Comments from Greenspace

APPLICATION EG/22/19/OUT

Site Address: Boweries Barnham Road Eastergate PO20 3RT

Description of Works: Outline application with some matters reserved for the erection of 28 No. dwellings, access, landscaping & associated works (resubmission following EG/42/18/OUT).

client			
Domusea Limited			
project			
The Boweries Barnham Road Eastergate			
title			
Wider Development and Landscape Framework Plan			
date	scale @ A3	drawn	chkd
Jan 2019	1:1500	MRL	GBC
project no.	drawing no.	rev	
1815	1000	P01

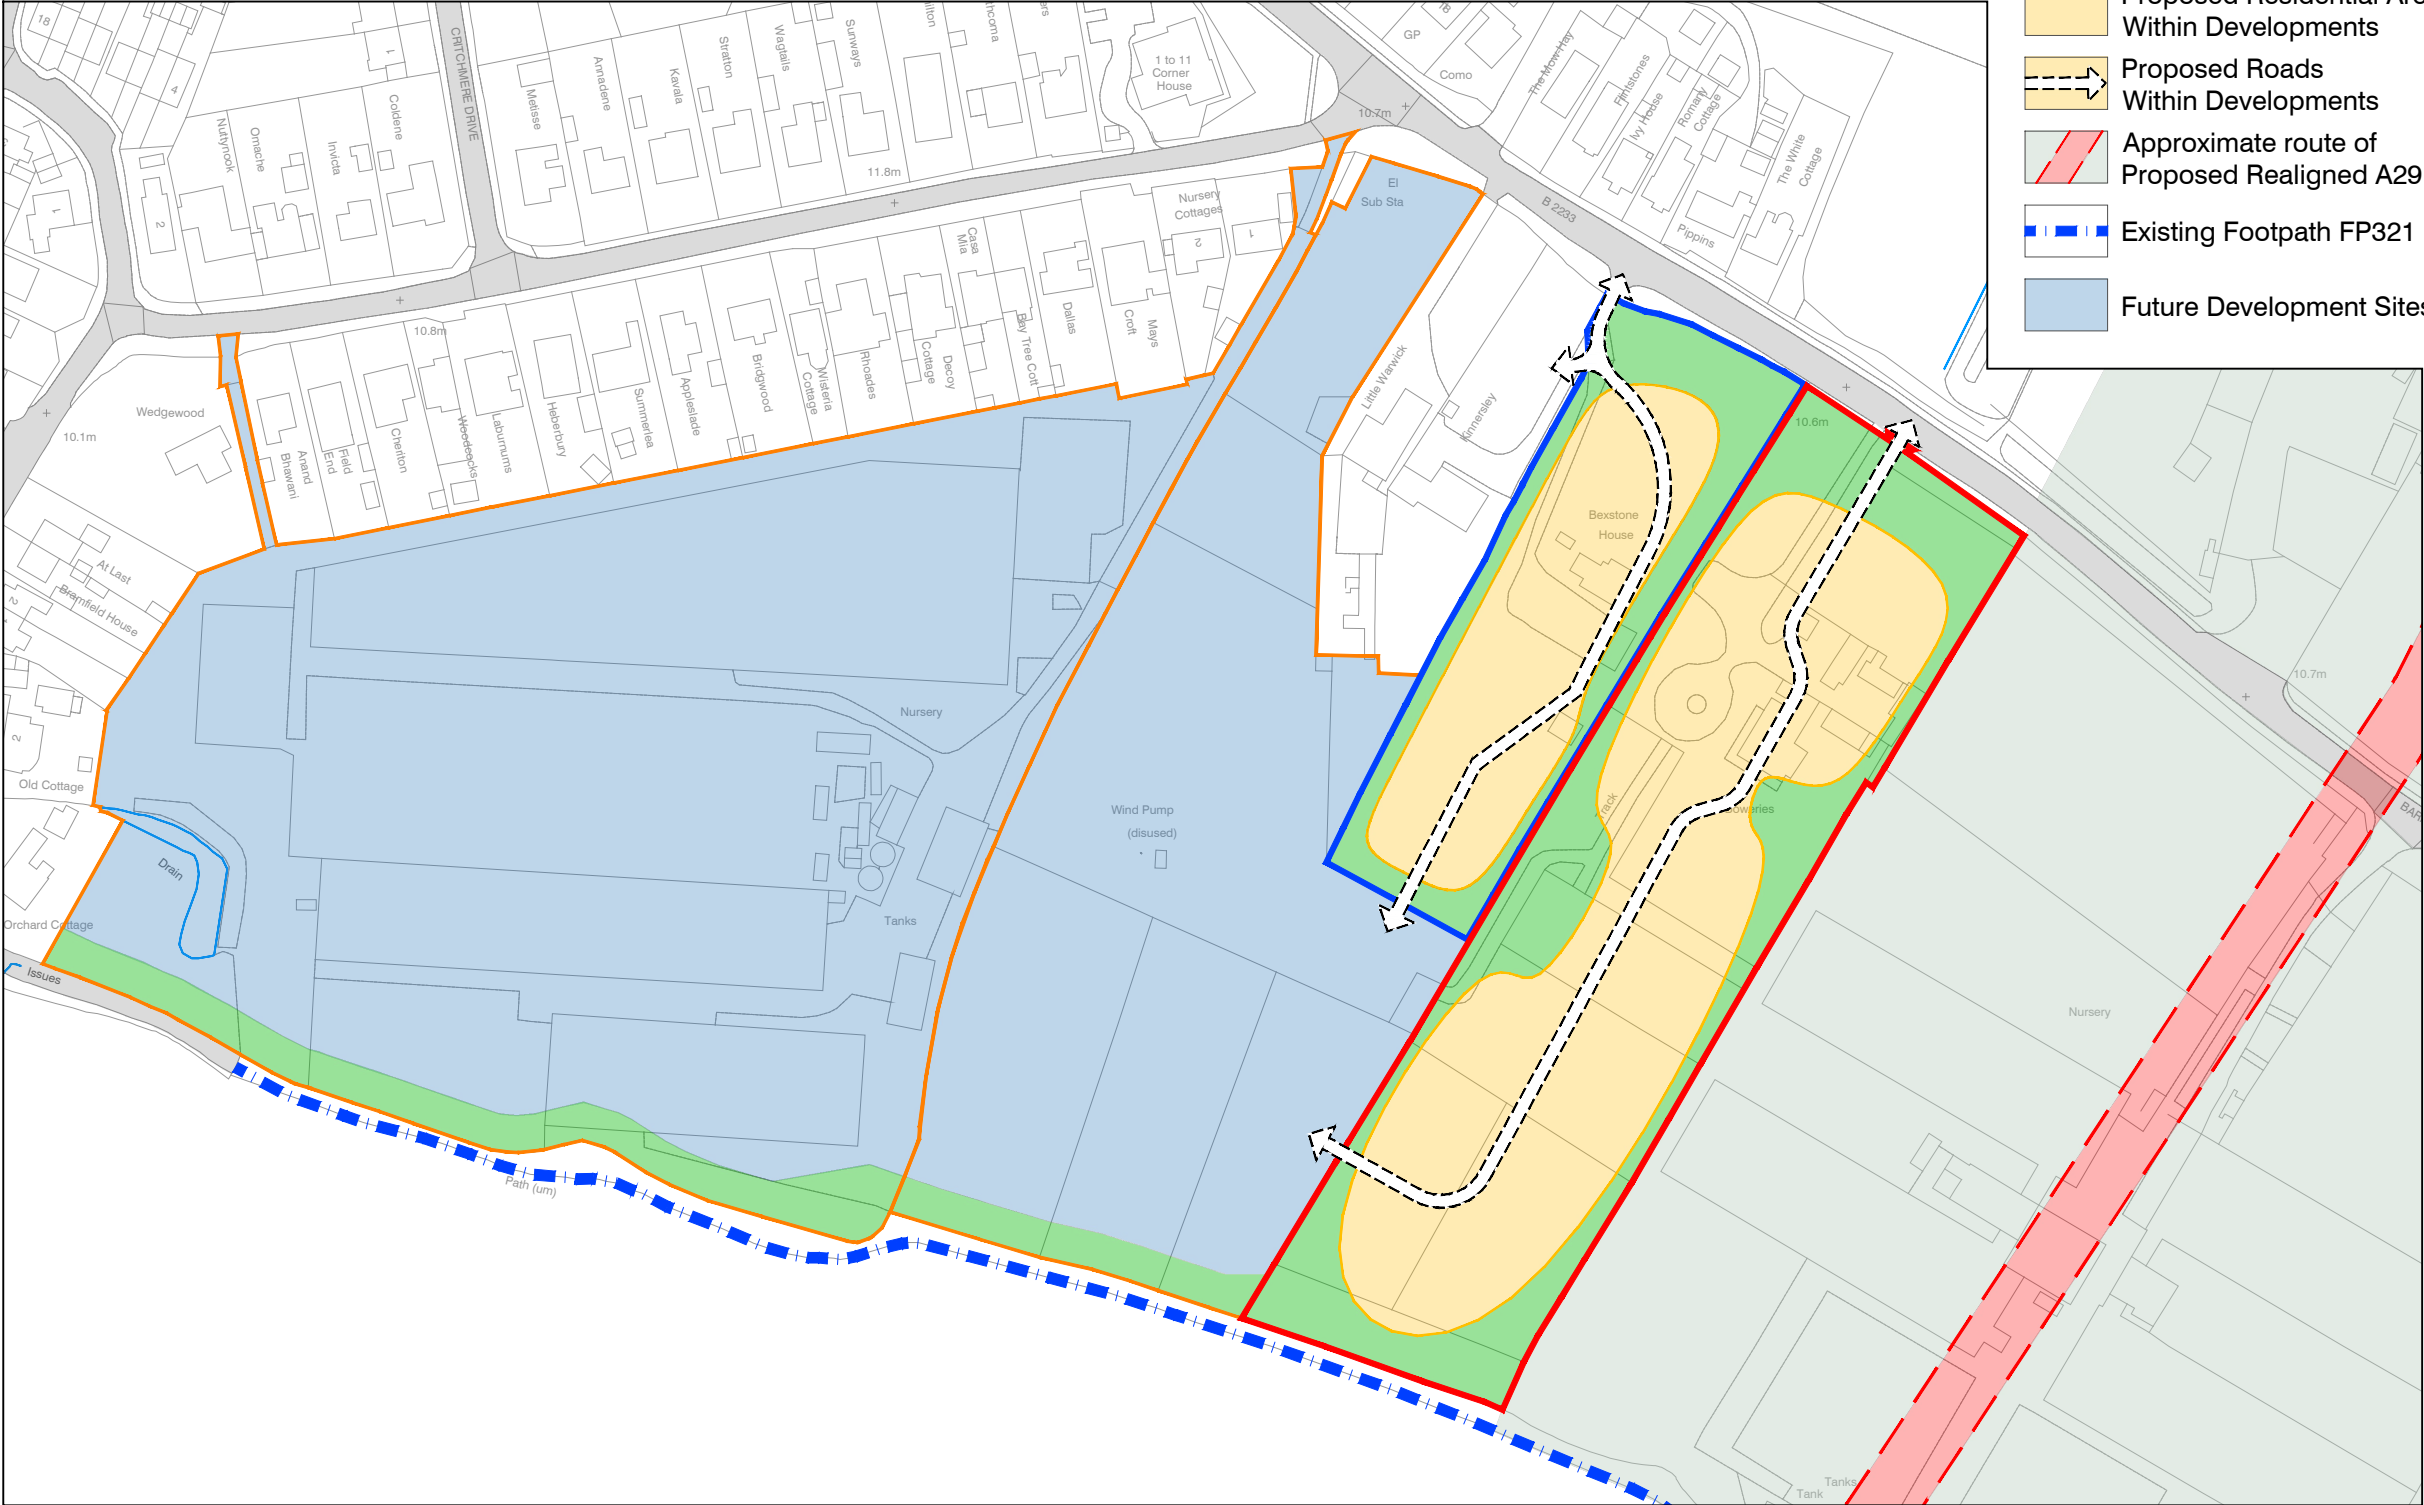
It is encouraging to see that the red line development has been shown in conjunction with the masterplan for the wider area. It is not clear however how the existing trees within the site are to be accommodated and also how the connectivity with the adjacent site will be demonstrated. There would appear to be noted existing tree presence on this site with some detailed for removal in order that the development could proceed. Details of this tree loss would need to be shown along with the mitigation planting to be introduced with the proposals.
